From: Michael Eastham <Michael.Eastham@arun.gov.uk>
Sent: 25 March 2021 11:17
To: Planning.Responses <Planning.Responses@arun.gov.uk>
Cc: Carol Reynolds <Carol.Reynolds@arun.gov.uk>
Subject: Discharge of condition application A/39/21/DOC - Land south of Water Lane

Please upload onto Ocella the email below which is a consultation response from **Environmental Health** to discharge of condition application **A/39/21/DOC**.

Subject: FW: Planning Consultation on PAA/4/20/ and previous A/99/17/OUT Land south of Water Lane

Figure 9.3: Noise Levels in Communal Amenity Space Serving Block A

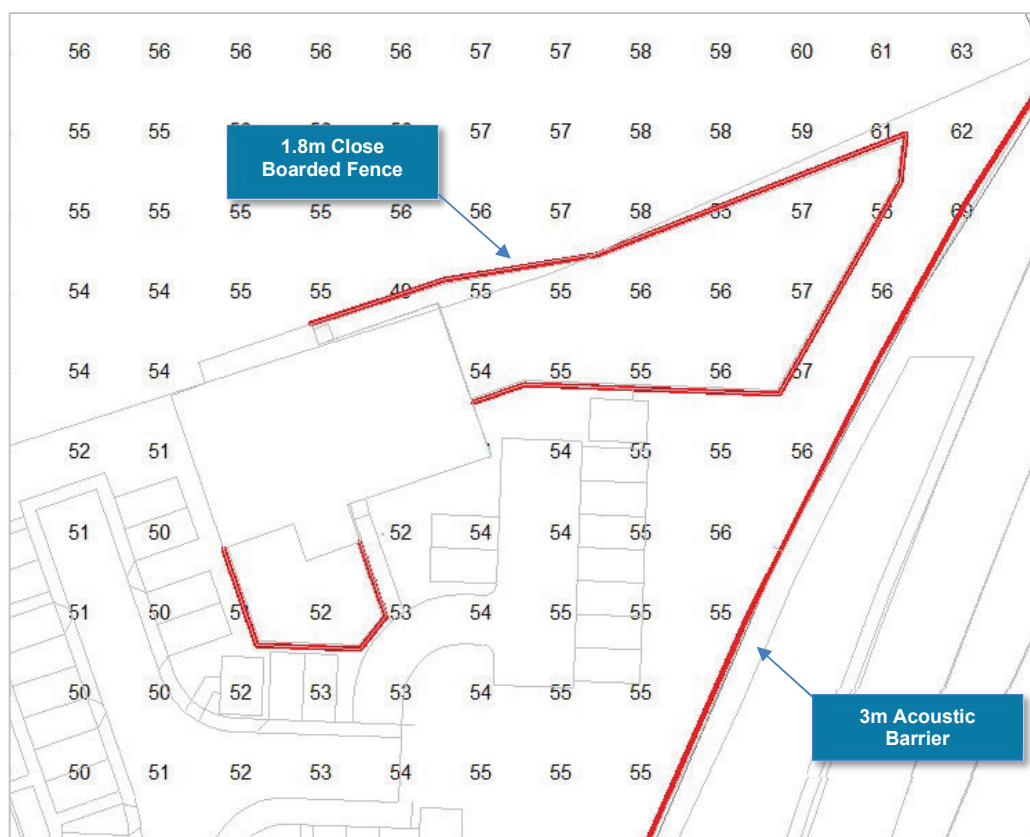
Thank you for discussing that matter of the acoustic barrier as below with me this morning. As stated, I have not yet read the acoustic report in this case, but am aware of too high levels of noise from traffic in the amenity space to flats as detailed below. In this case a higher acoustic fence is indicated, which I believe Mayer Brown acousticians have specified as 3 - 3.5m. This will be necessary to reduce noise levels to a more acceptable level.

Your colleague Paul Gray very kindly phoned me back today. To answer your query, with only distant access to any area of open space, then my advice is that a suitable acoustic barrier should be provided north and east to surround the amenity space to flats at the far north-east of this site. This is in order to bring noise from adjacent roads to within the 55db (significant annoyance) and much more preferably 50db (moderate annoyance) criteria for outdoor amenity areas, as guided by BS8233.
